Subject: Rezoning Petition Review

Rezoning Petition #: 22-051

Location of Property: Approximately 4.98 acres located on the south side of Sam Neely Rd, west of Steele Creek Rd and east of Krislyn Woods Pl.

CONCEPT PLAN - SF ATTACHED

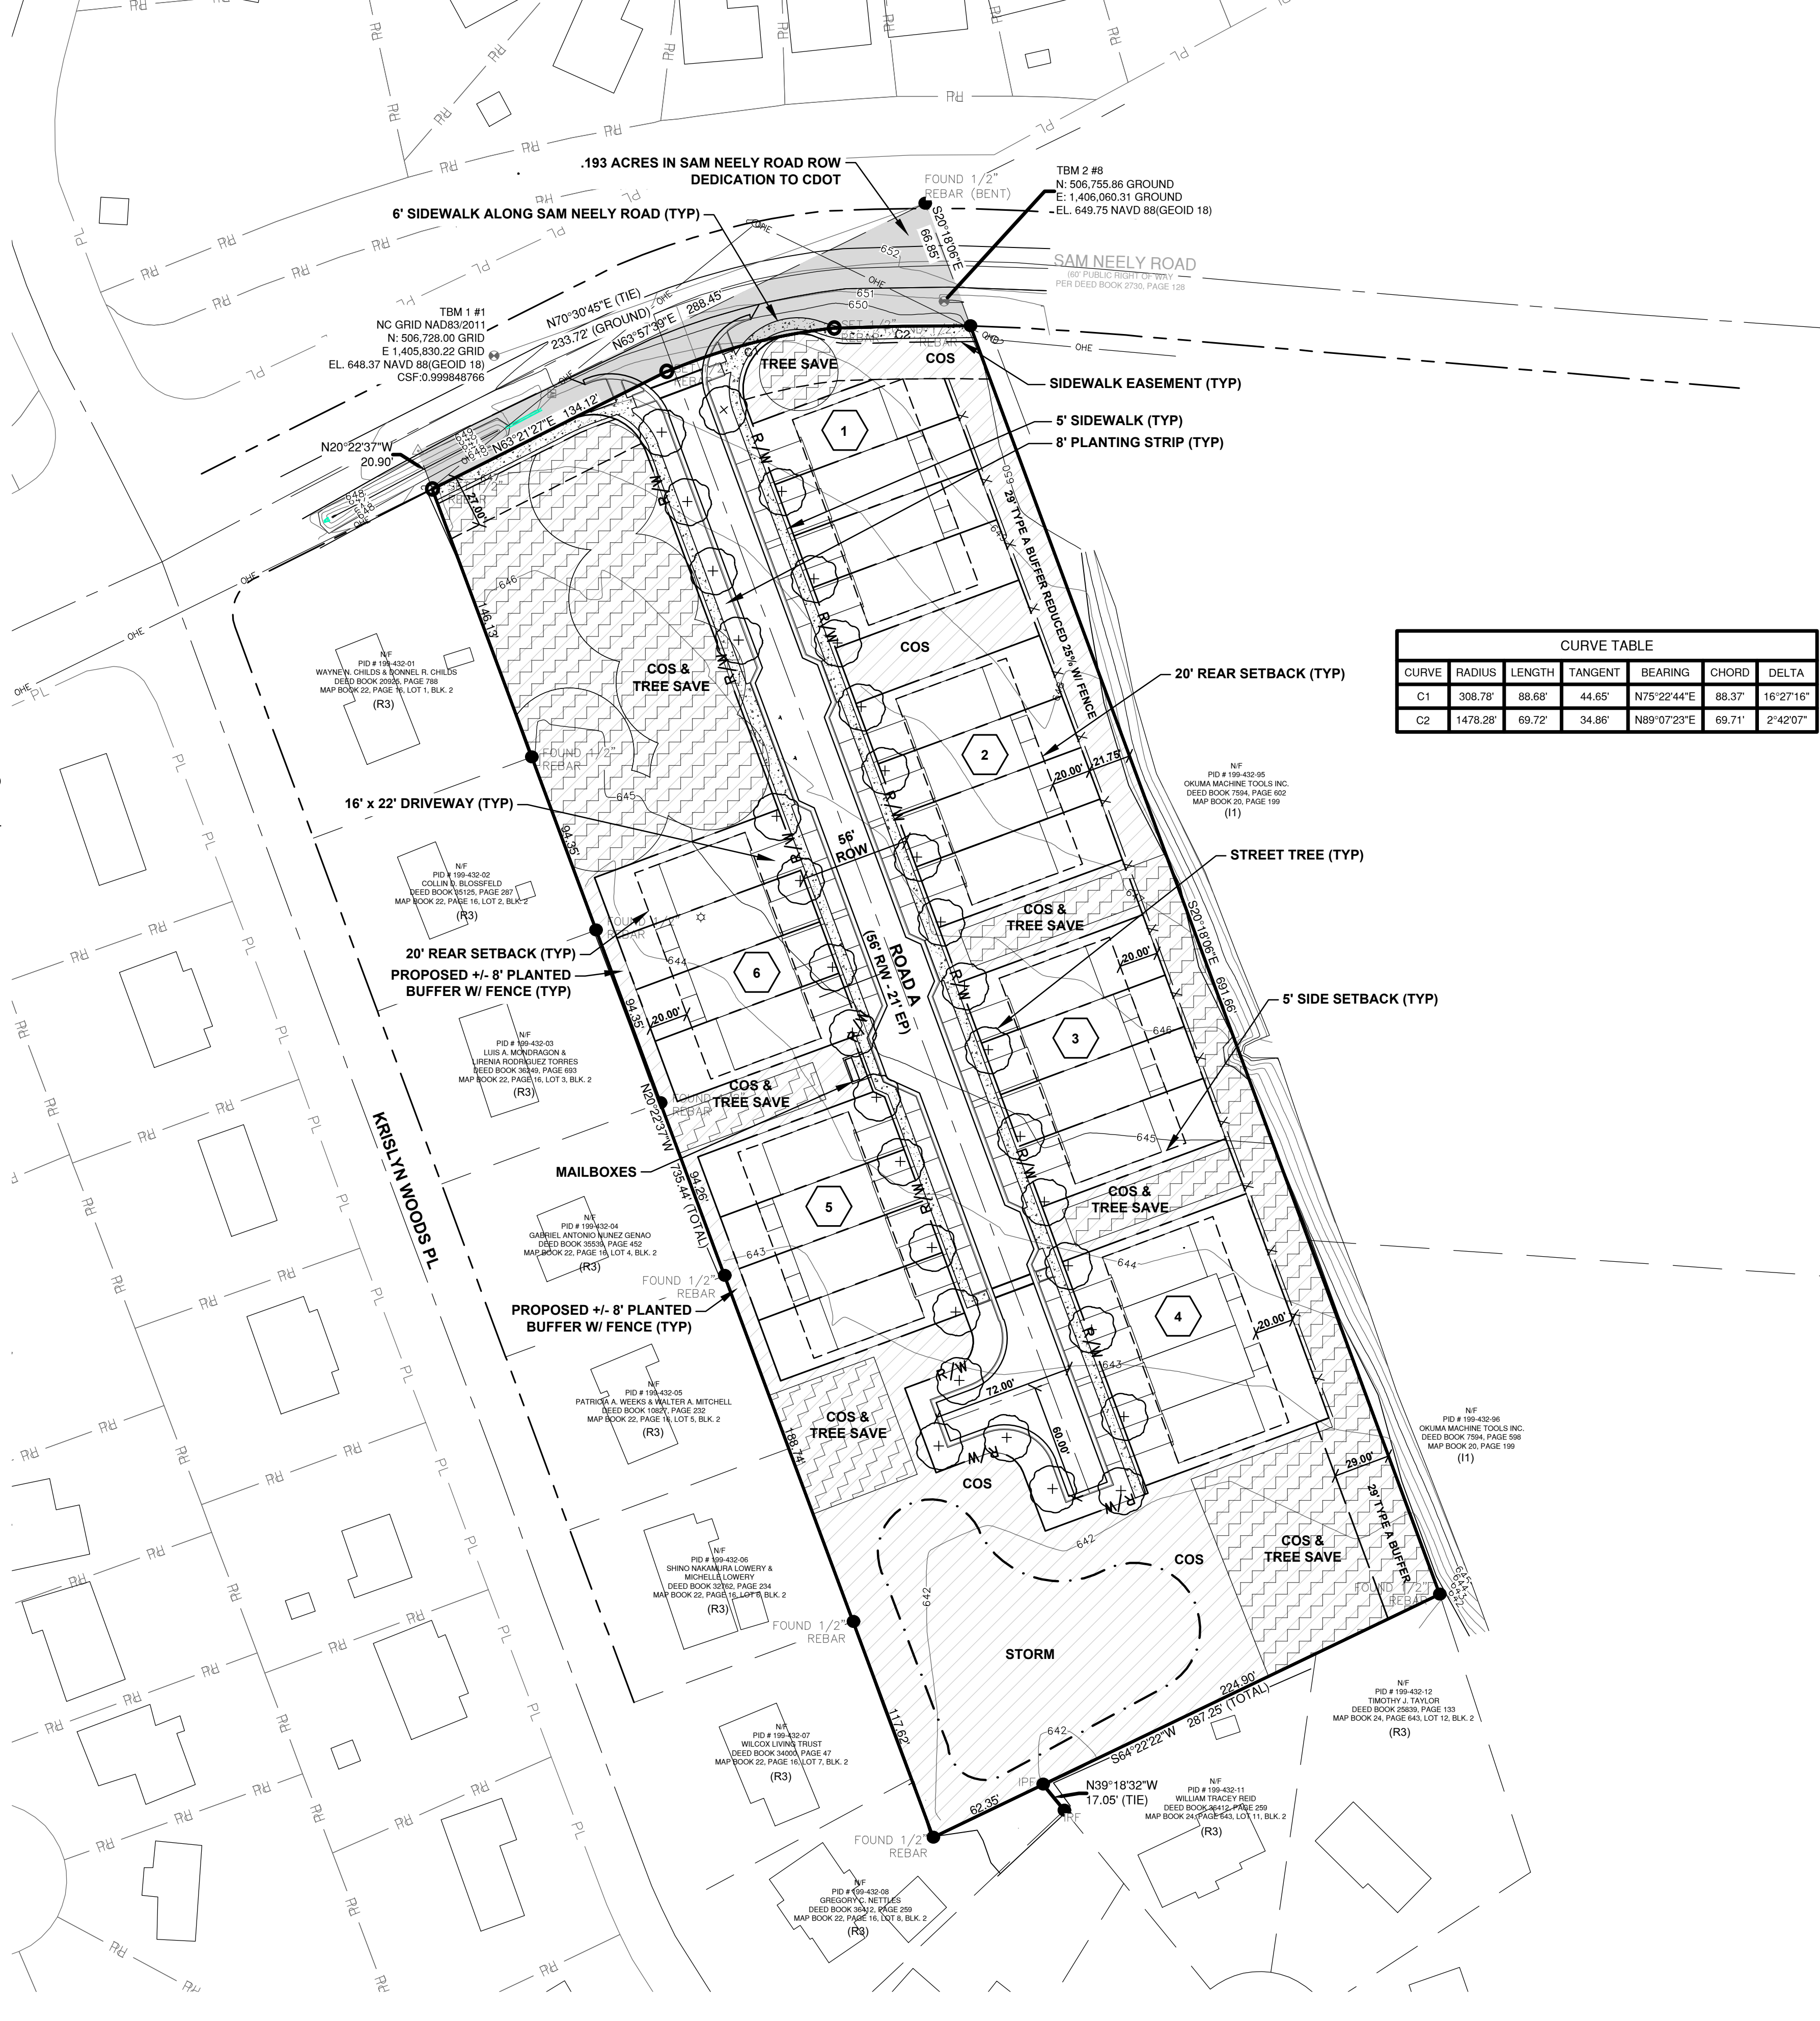
Please add the following note under the *Environmental Notes*: For adjoining parcels receiving stormwater discharge from the proposed BMP/Water Quality feature, the petitioner shall analyze the adequacy of the existing stormwater conveyance on the adjoining parcels. If the existing stormwater conveyance on the adjoining parcels is found to be inadequate, the Petitioner shall make a good faith effort with the property owner(s) to improve the stormwater conveyance or mitigate the stormwater discharge onto the adjoining parcels.

This property drains to Steele Creek, which is an impaired/degraded stream, and may contribute to downstream flooding. This project has the opportunity to mitigate future impacts to this stream, therefore, Storm Water recommends placing the following notes on the plan:

For defined watersheds greater than 24% built-upon area (BUA), construct water quality stormwater control measures (SCMs) designed for the runoff generated from the first 1-inch of rainfall for all new and redeveloped BUA associated with the project. SCMs must be designed and constructed in accordance with the Charlotte-Mecklenburg BMP Design Manual.

For defined watersheds greater than 24% built-upon area, control the entire volume for the 1-year, 24-hour storm for all new and redeveloped BUA associated with the project. Runoff volume drawdown time shall be in accordance with the Charlotte-Mecklenburg BMP Design Manual.

For commercial projects with greater than 24% BUA, control the peak to not exceed the predevelopment runoff rates for the 10-yr, 6-hr storm and perform a downstream flood analysis to determine whether additional peak control is needed and if so, for what level of storm frequency, or if a downstream analysis is not performed, control the peak for the 10-yr and 25-yr, 6-hour storms.

For residential projects with greater than 24% BUA, control the peak to not exceed the predevelopment runoff rates for the 10-year and 25-year, 6-hour storms or perform a downstream analysis to determine whether peak control is needed, and if so, for what level of storm frequency.
